February 23, 2018

**RE: Boulders Phase 3
Engineers Certification for Release of Financial Guarantee
Grading and Drainage Plan Stamp Date: 1/28/14
Certification Date: 2/14/18
Hydrology File: B10D001D**

Based on the Engineers Certification received on 2/14/18, this project cannot be considered for Release of Financial Guarantee by Hydrology until the following are corrected:

ENGINEER'S SEAL	THE BOULDERS PHASE 3	DRAWN BY DY
		TRACT 6A GRADING AND DRAINAGE PLAN	DATE 1-27-14
		TERRA WEST, LLC 5571 MIDWAY PARK PLACE NE ALBUQUERQUE, NM 87109 (505)858-3100 tierreastllc.com	Offsite-Pond
	VINCENT P. CARRICA P.E. #16212		SHEET # 3 JOB # 2011005

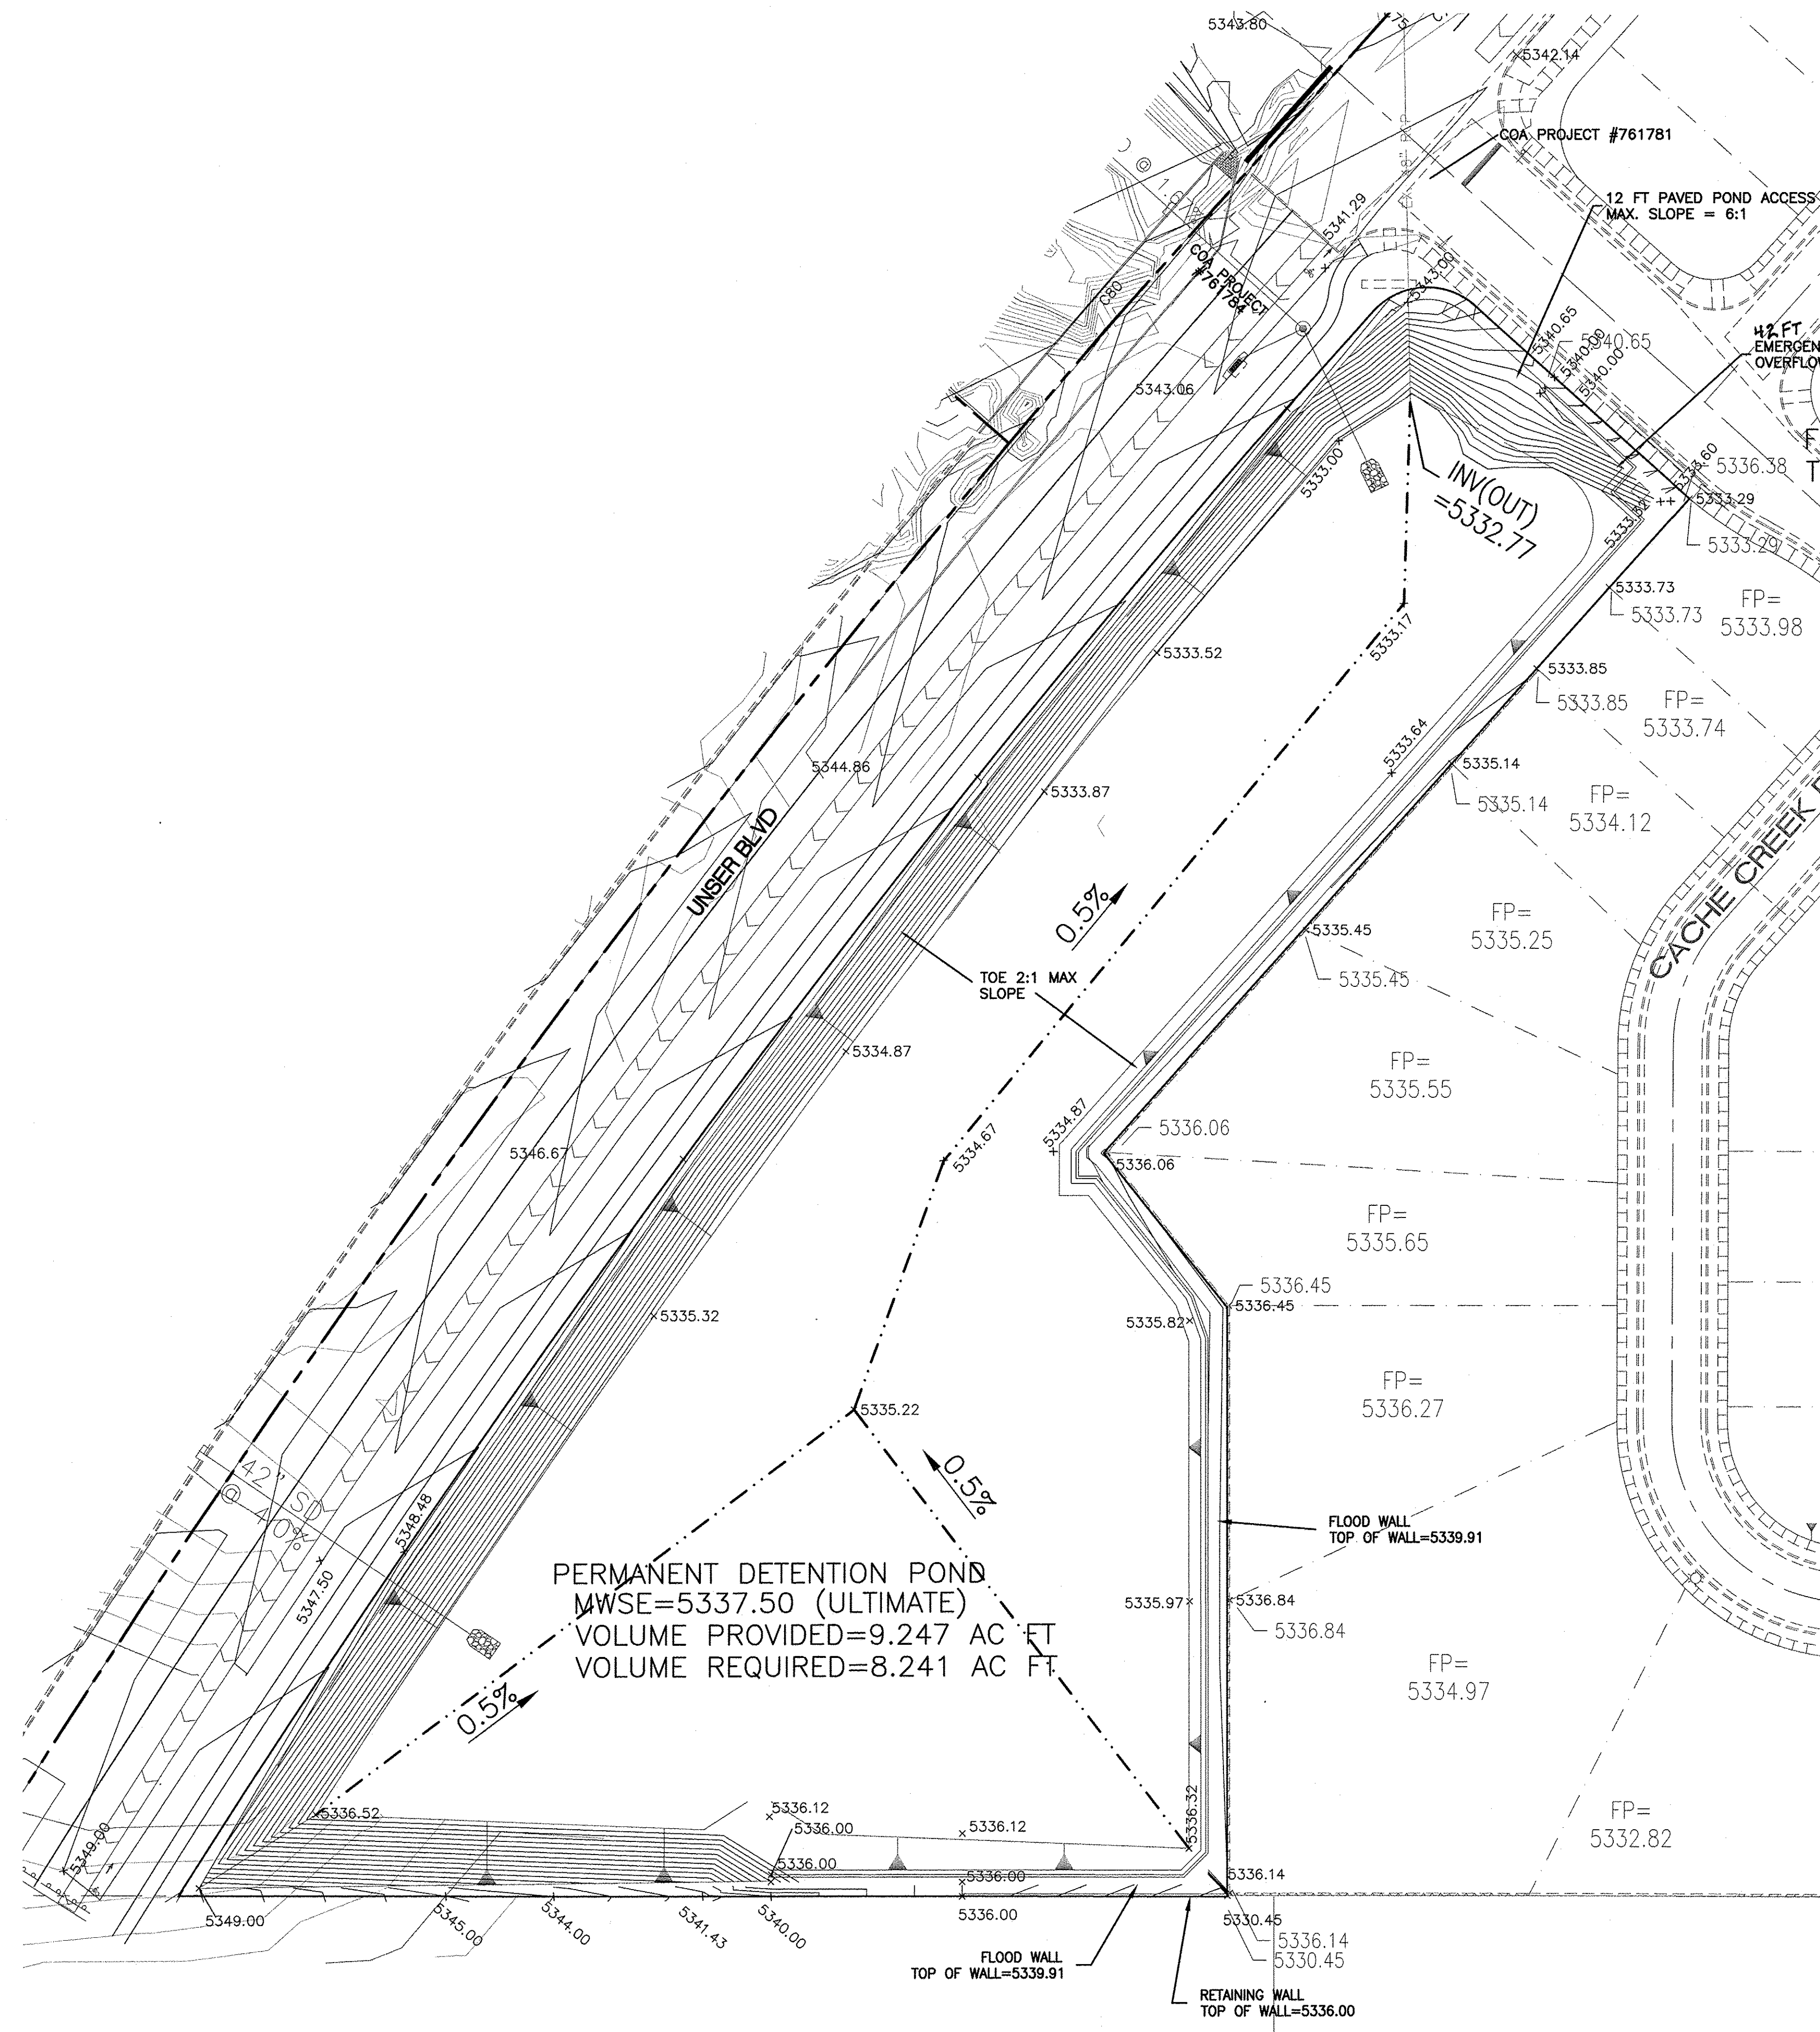
1. The entire Grading Plan needs to be as-built, certified, and complete for a complete release of financial guarantee. This includes Sheet 3 of the approved Grading Plan (Tract 6A Grading and Drainage Plan) and Unser. If the intent is to shift the pond improvements to the Unser SIA and not construct them at this time, then only a reduction of financial guarantee (exclusive of the pond and Unser improvements) can be considered. A cover letter or statement on the Certification, explaining such circumstances and signed by the engineer, would be helpful in this case.
